Conservation Area Advisory Committee

BR/198/18/HH

Demolition of existing outbuilding & erection of two storey extension. This application affects the character & appearance of The Steyne, Bognor Conservation Area.

Milford Cottage Market Street Bognor
Regis PO21 1TD

Scale 1:50		Applicant: Angela Taylor Address: Milford Cottage Bognor Regis PO21 1TD	
Project: Two-storey extension		Revision date: PLA002	
Scale: 1:50 @ A1		Date: 11/07/2018	
Title: Proposed floor plan and elevations		Plan No: PLA002

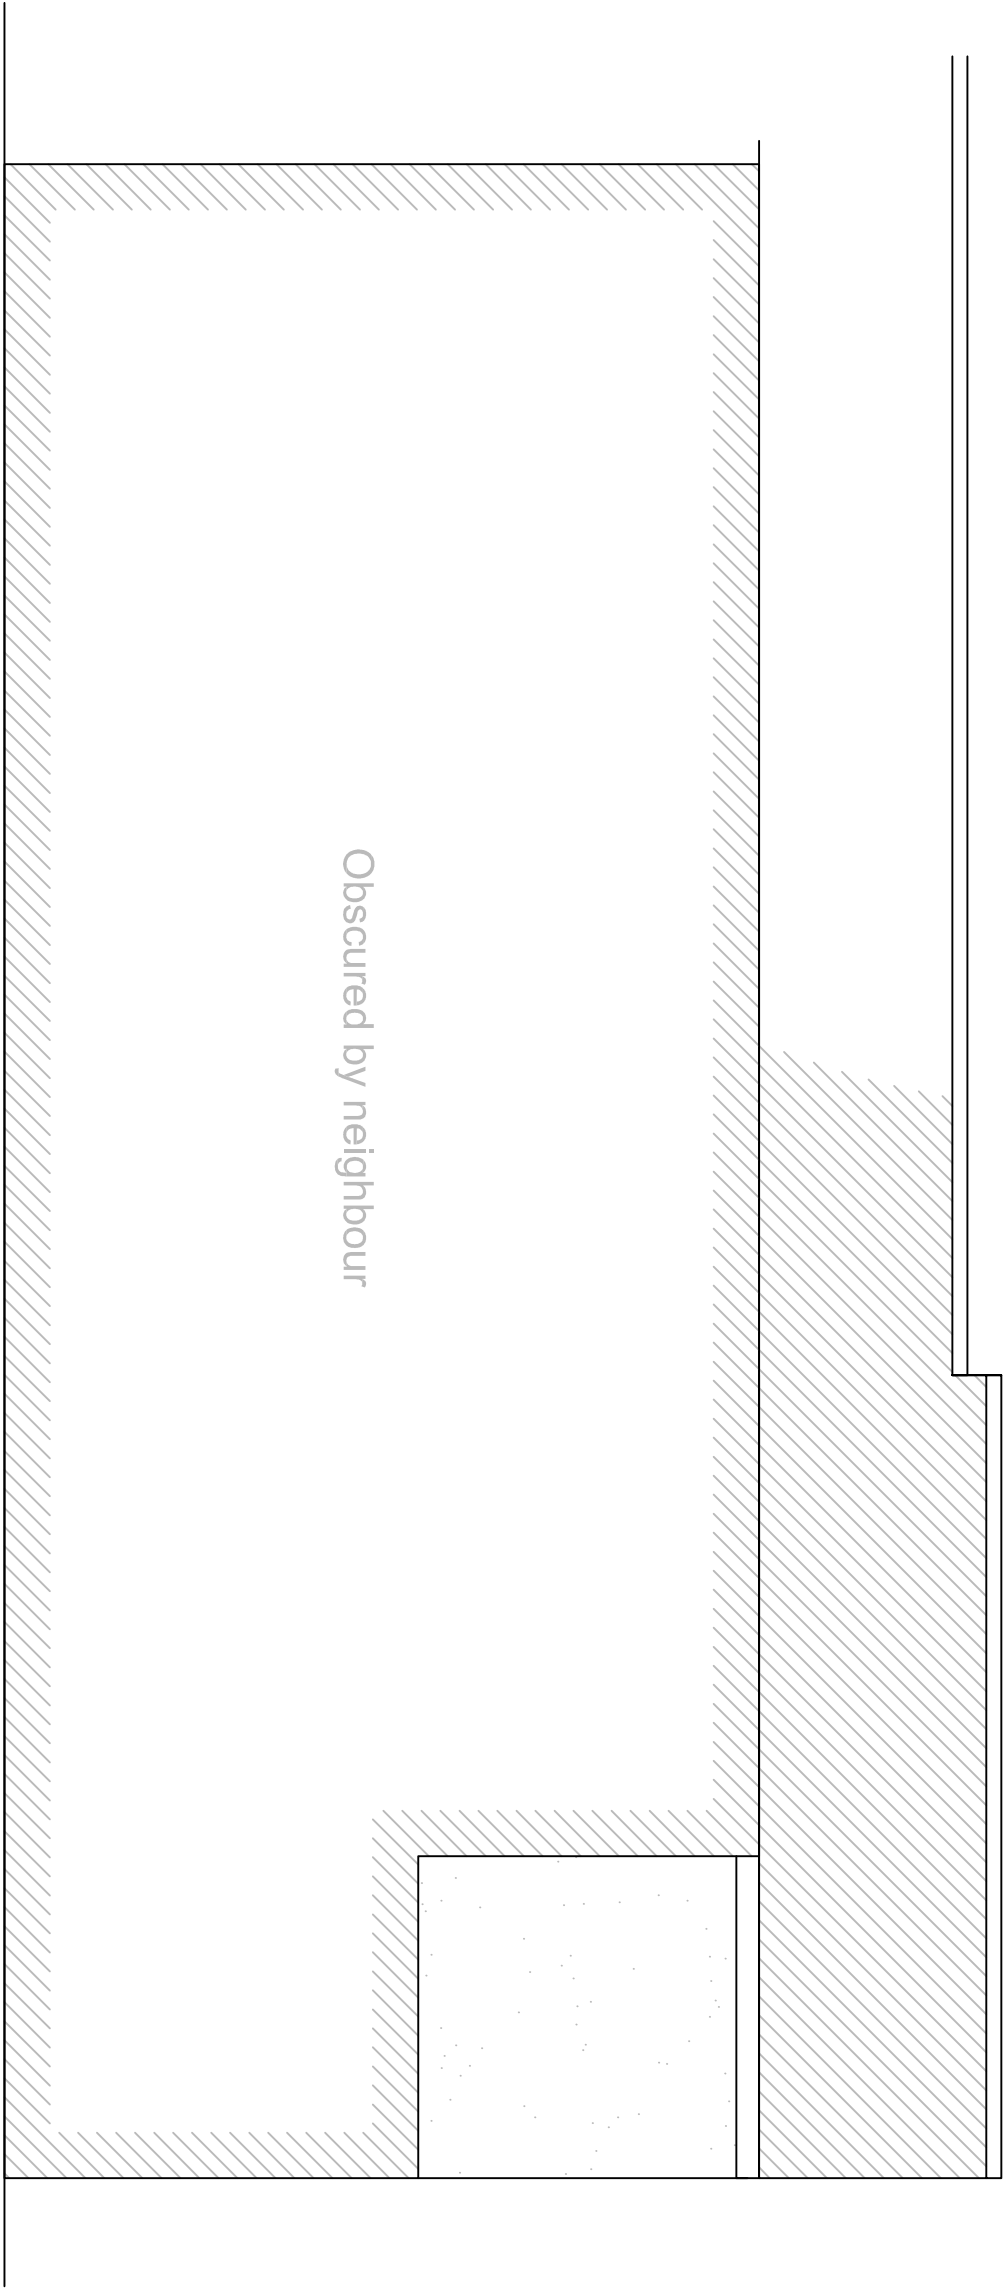
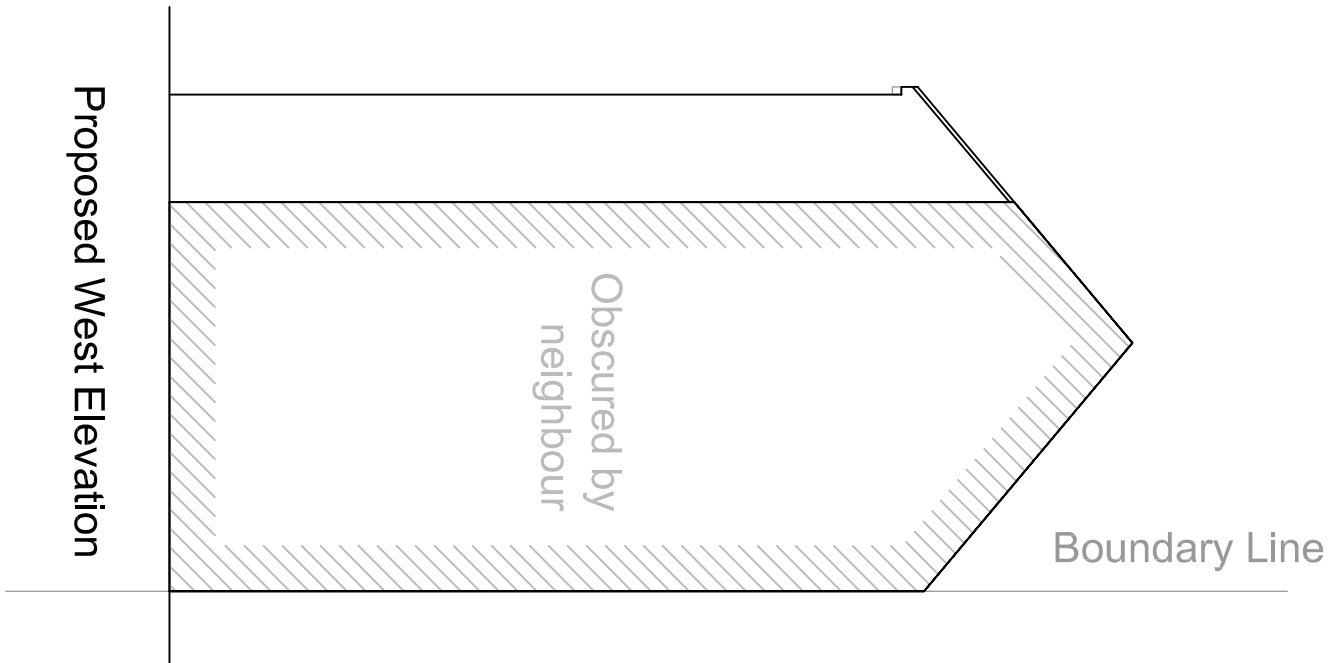
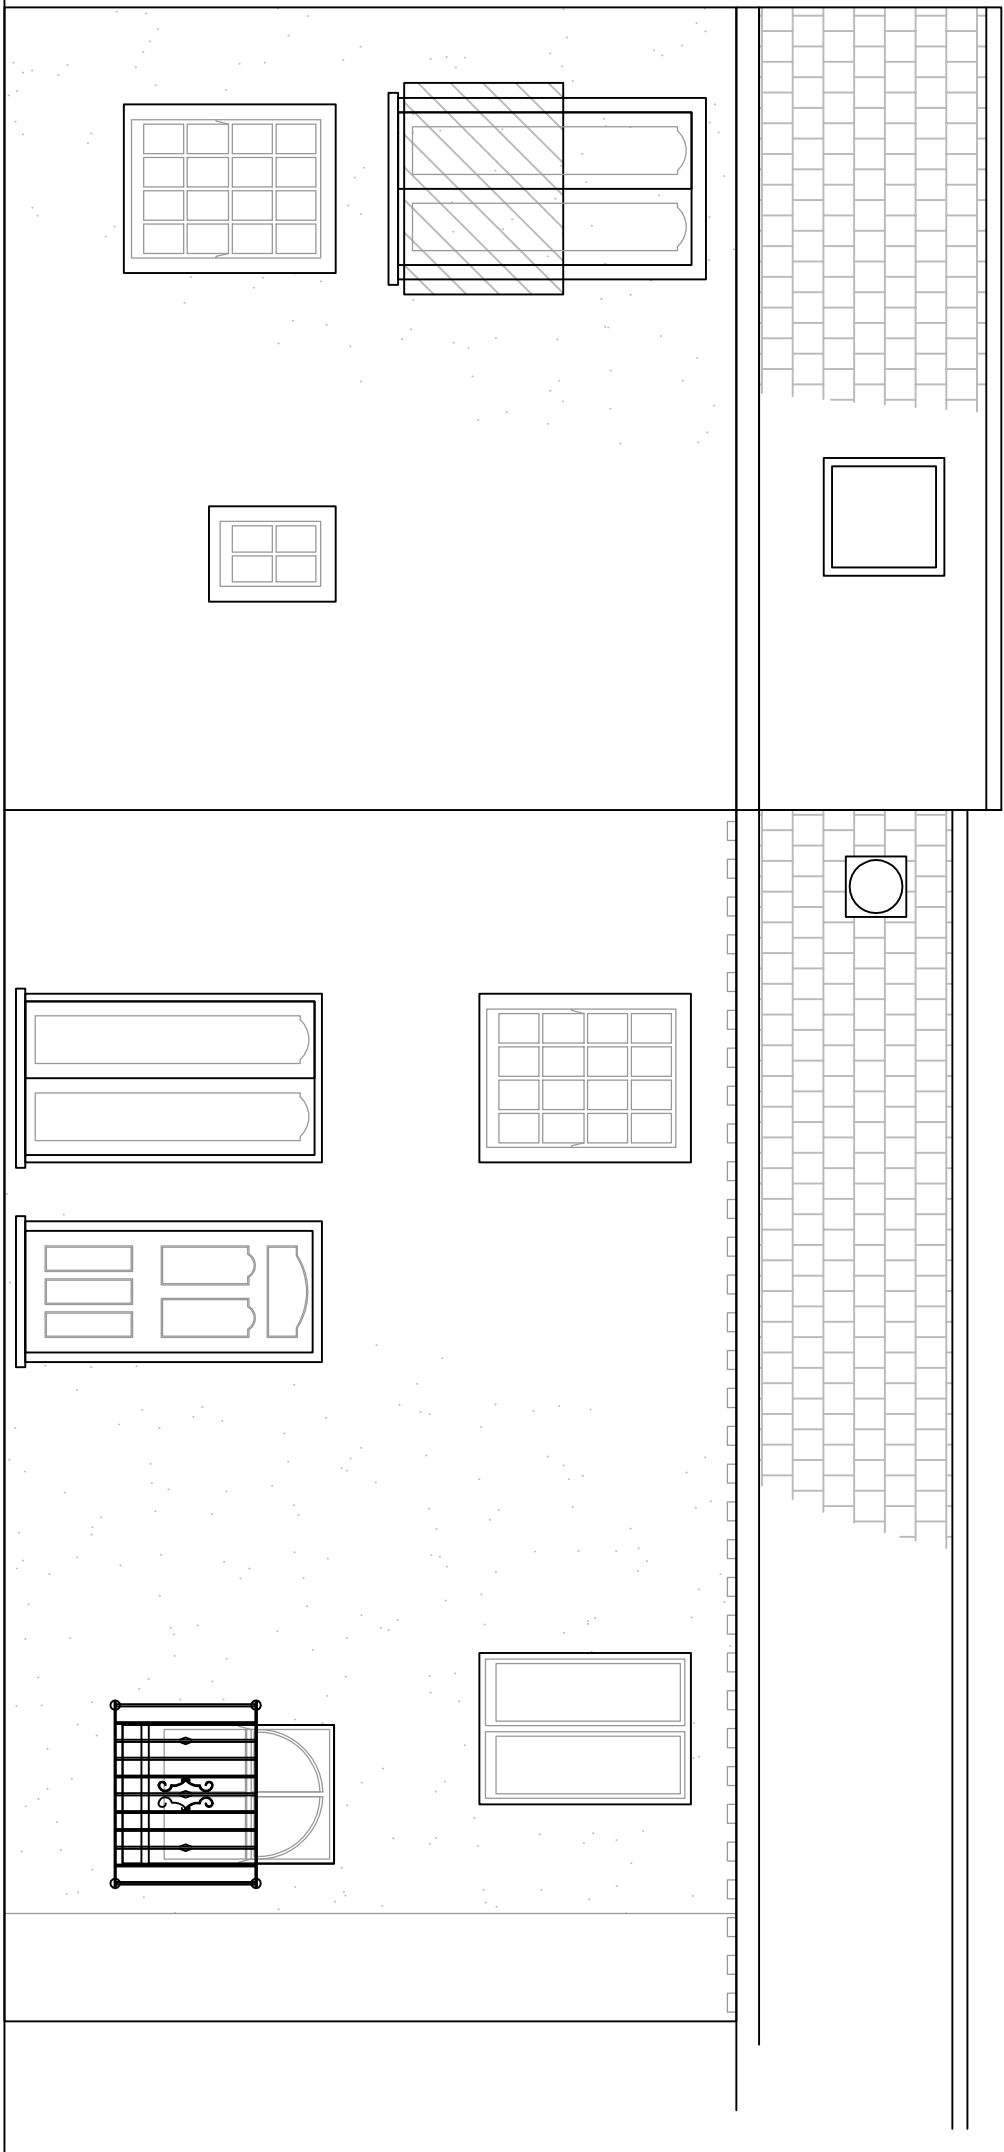
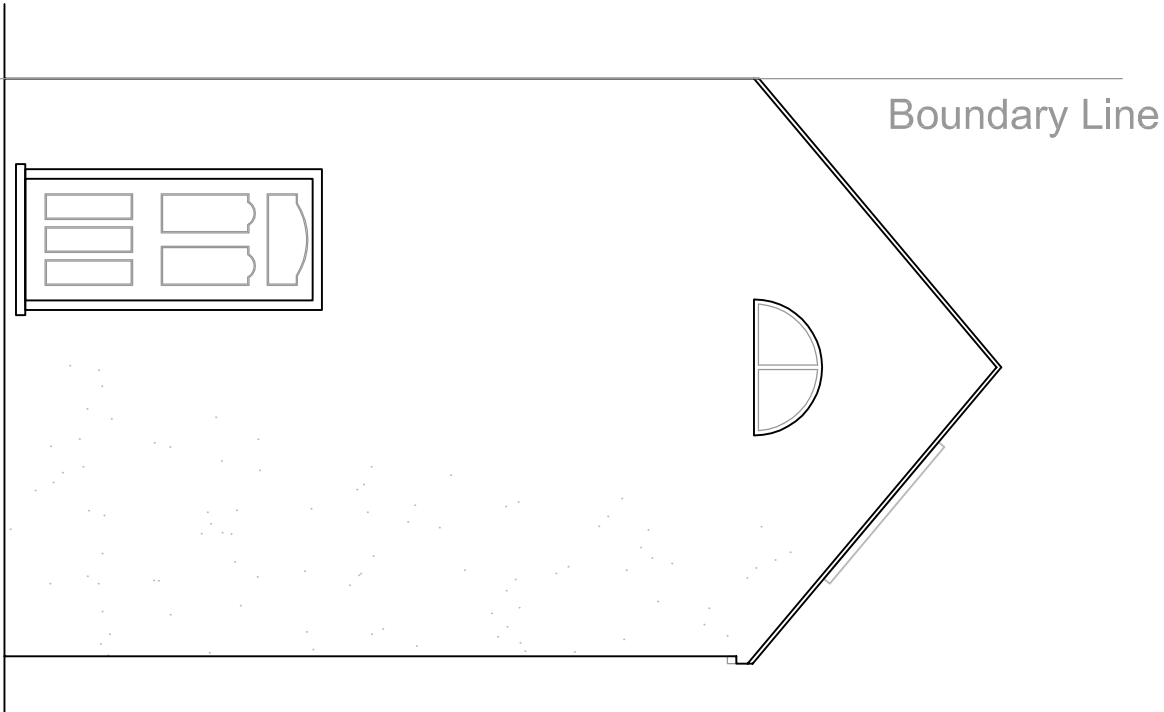
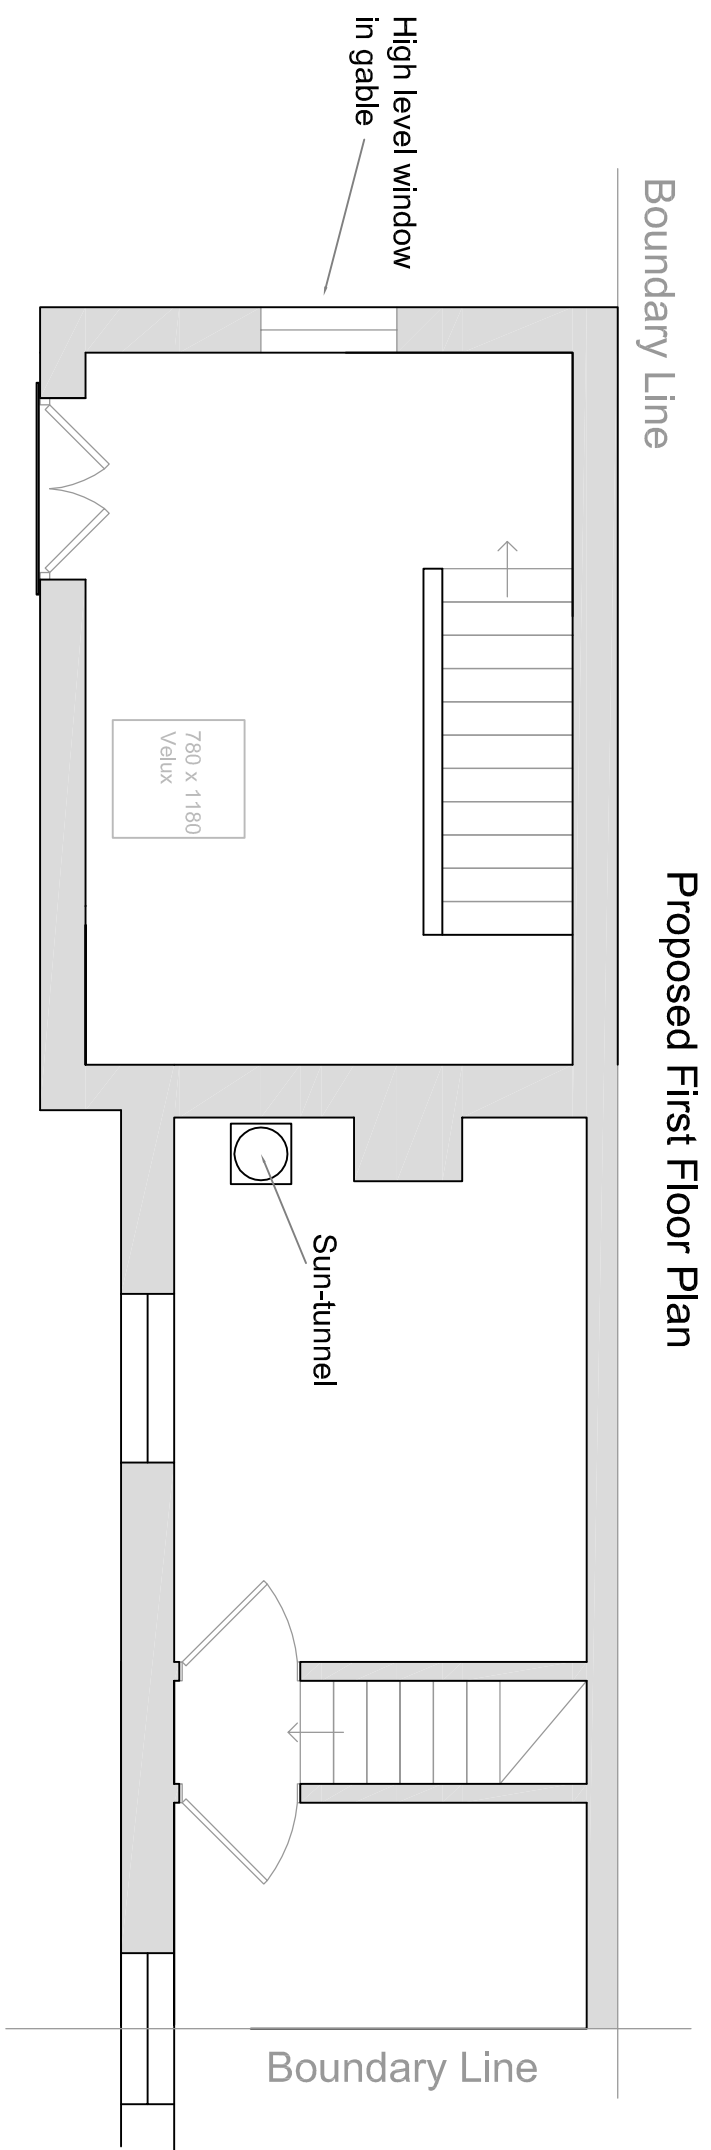
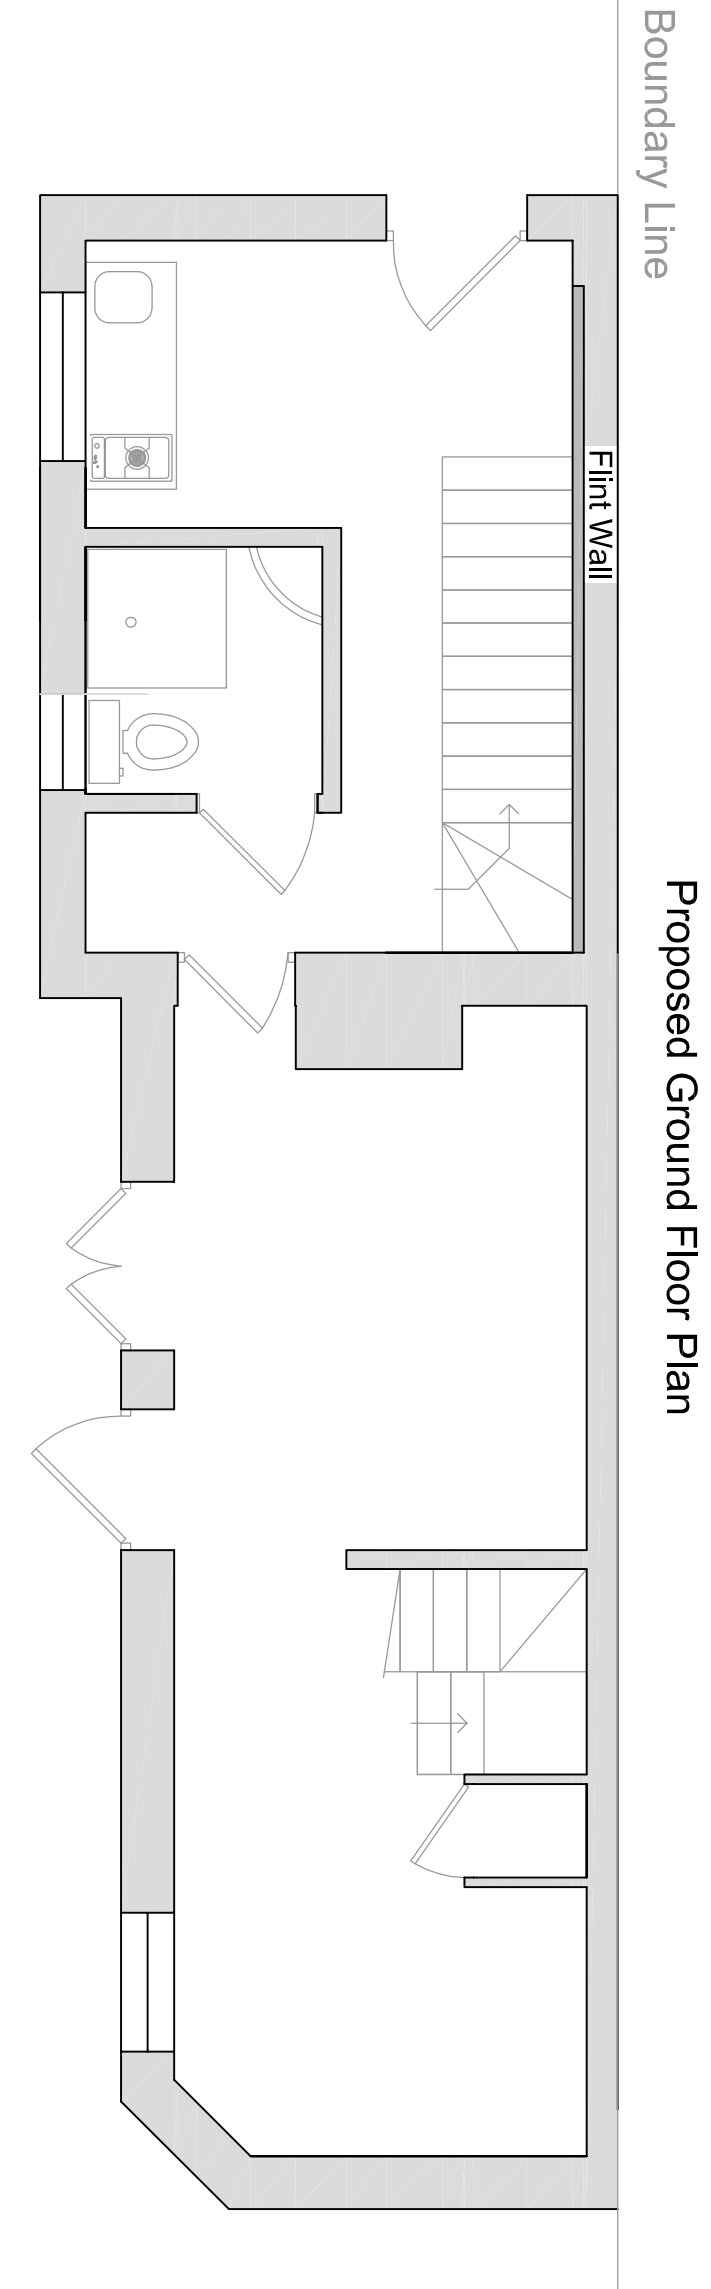
OBJECTION

Poor window + door unit
